HERTFORDSHIRE ECOLOGY

Your Ref: 6/2018/0171/MAJ
Ask for: M J Hicks
Tel: 01992 556158
Date: 25/4/18

Application: Creation of a mixed-use quarter... plus associated car parking, access, landscaping, public art and other supporting infrastructure.
Address: Former Shredded Wheat Factory Welwyn Garden City AL8 6UN
Application No: 6/2018/0171/MAJ

SENSORY GARDEN

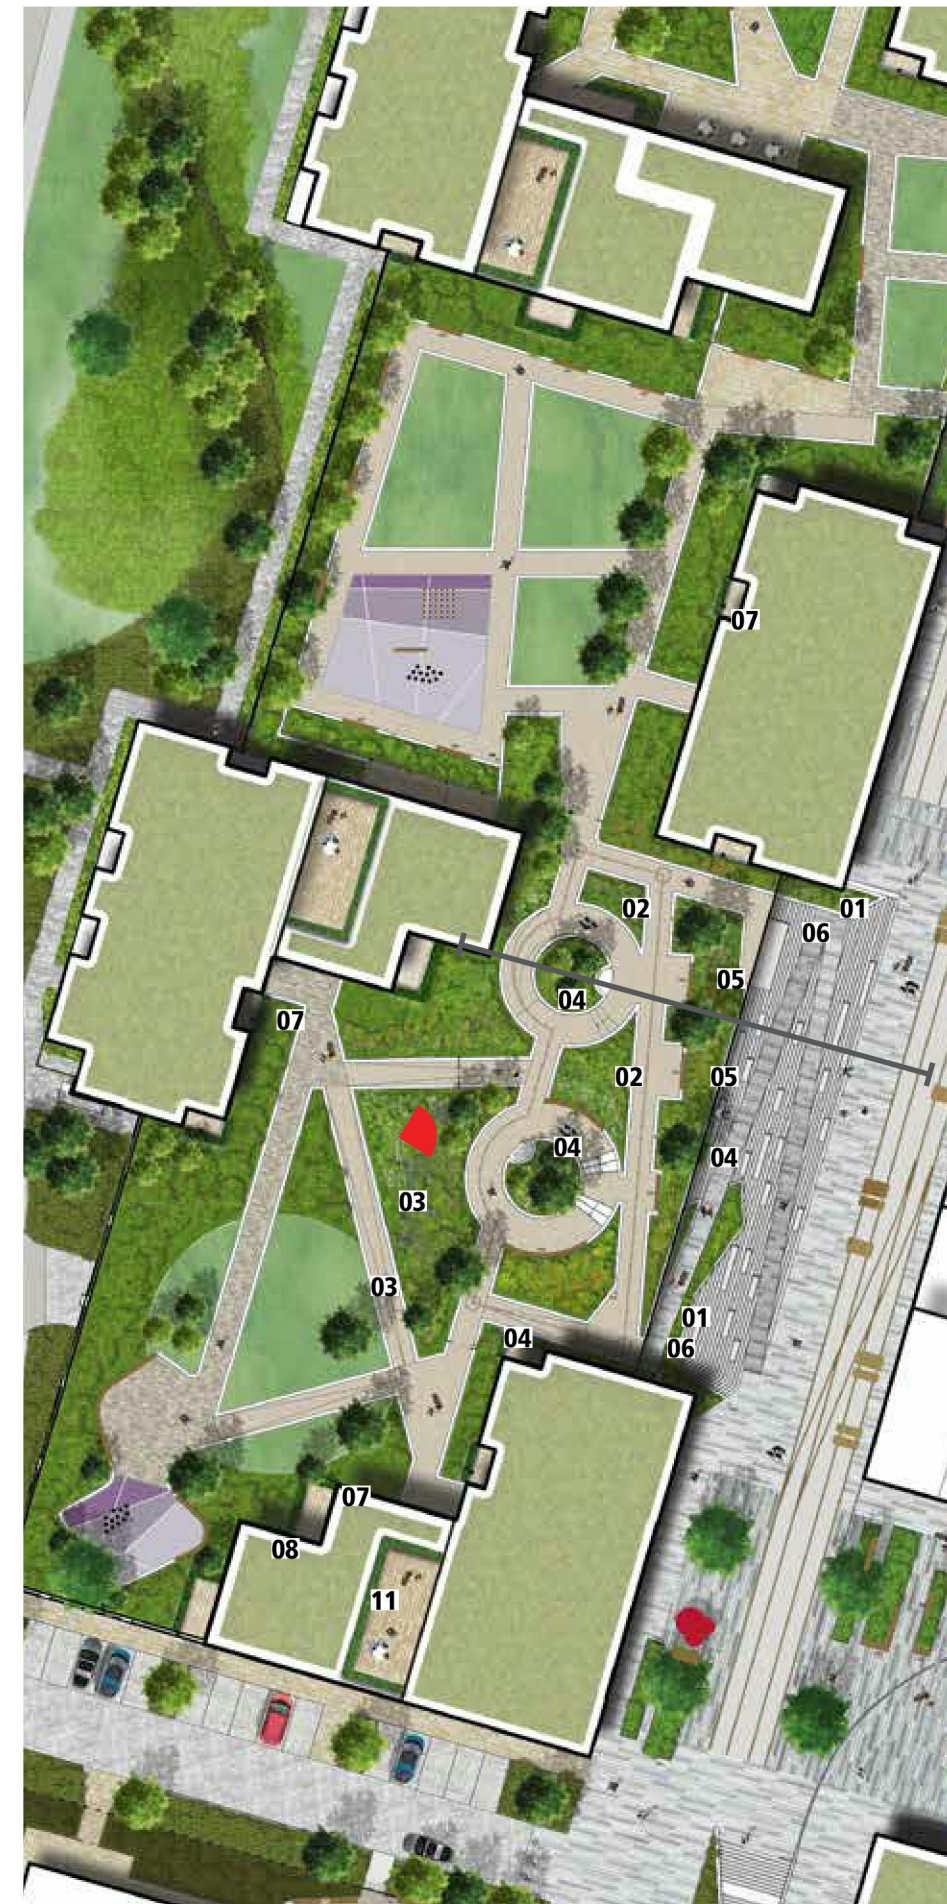
Consequently, whilst I support Howard's aspiration presented in support of 05 Landscape Proposals "*Parks and gardens, orchards and woods, are being planted in the midst of the busy life of the people, so that they may be enjoyed in the fullest measure...*" it is disappointing to note there does not appear to be any such functional landscaping proposed, at least as outlined within 5.3

Landscape Masterplan. Previously there was a mini-orchard. There is scope for improving this with traditional fruit tree management, espaliers, edible boundaries using plums, herb gardens, and perhaps even vegetable plots where possible. The nearest to this approach appears to be the proposed Sensory Garden. Any such landscaping would clearly better reflect the aspirations which it is implied this development will provide and would also bring biodiversity enhancements as well as ecosystem services. It would also encourage some direct engagement with the natural world within what will clearly be a modern urban environment.

Therefore whilst I don't object to the landscaping proposals, I consider they could be amended to incorporate such opportunities where appropriate.
